Have received below comments (see email) from our Drainage Advisor.

Thank you for reconsulting us on this application. The information submitted is insufficient to avoid the need for pre-commencement conditions.

ELEVATION OF HEADWALL OUTFALL TO POND / SIDE OF DITCH

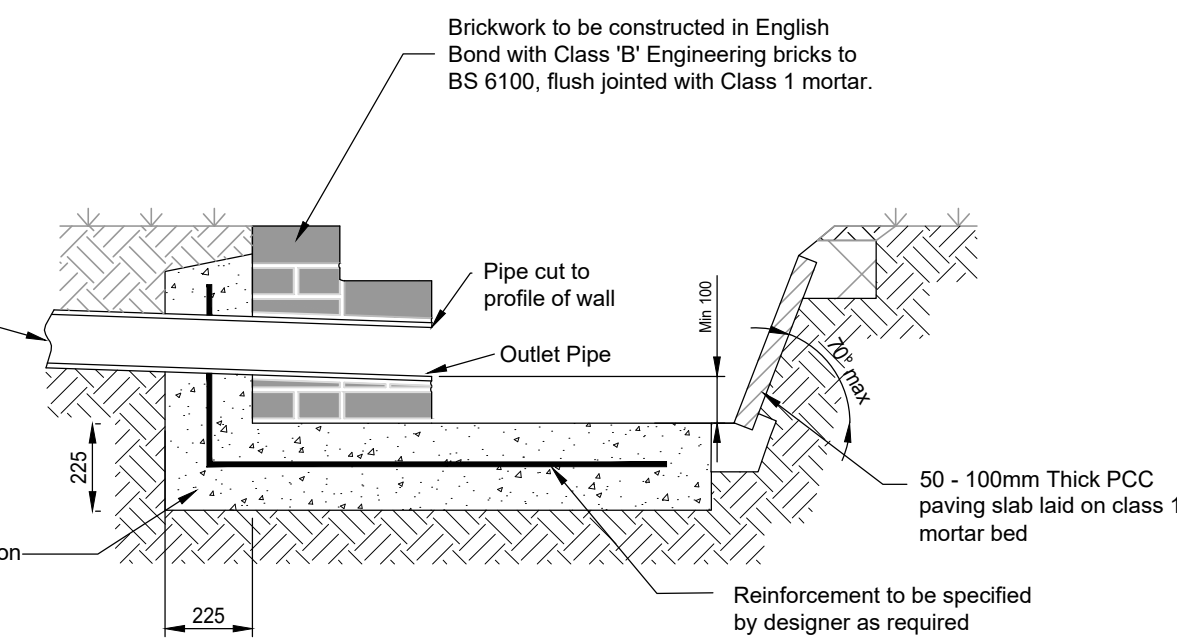
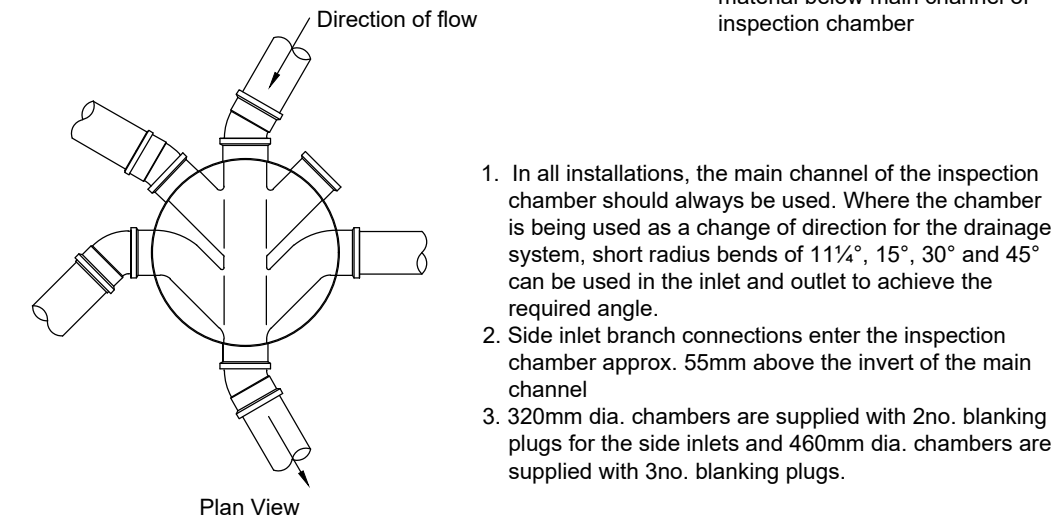
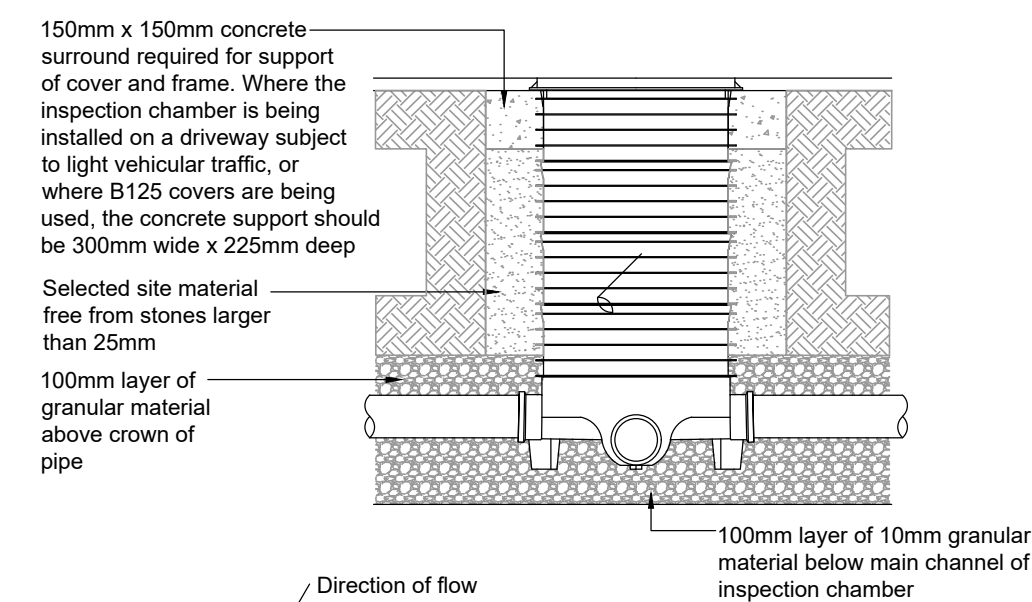
2. The drawing supplied shows a proposed connection to ordinary watercourse against the direction of flow, an alternative connection location is required.

PCENG03

“The development shall not proceed until details have been submitted to and approved in writing by the Local Planning Authority for any proposals: to discharge flows to watercourses; or for the culverting, diversion, infilling or obstruction of any watercourse on or adjacent to the site. Any discharge to a watercourse must be at a rate no greater than the pre-development run-off values. No construction is permitted, which will restrict current and future land owners from undertaking their riparian maintenance responsibilities in respect to any watercourse or culvert on or adjacent to the site. “
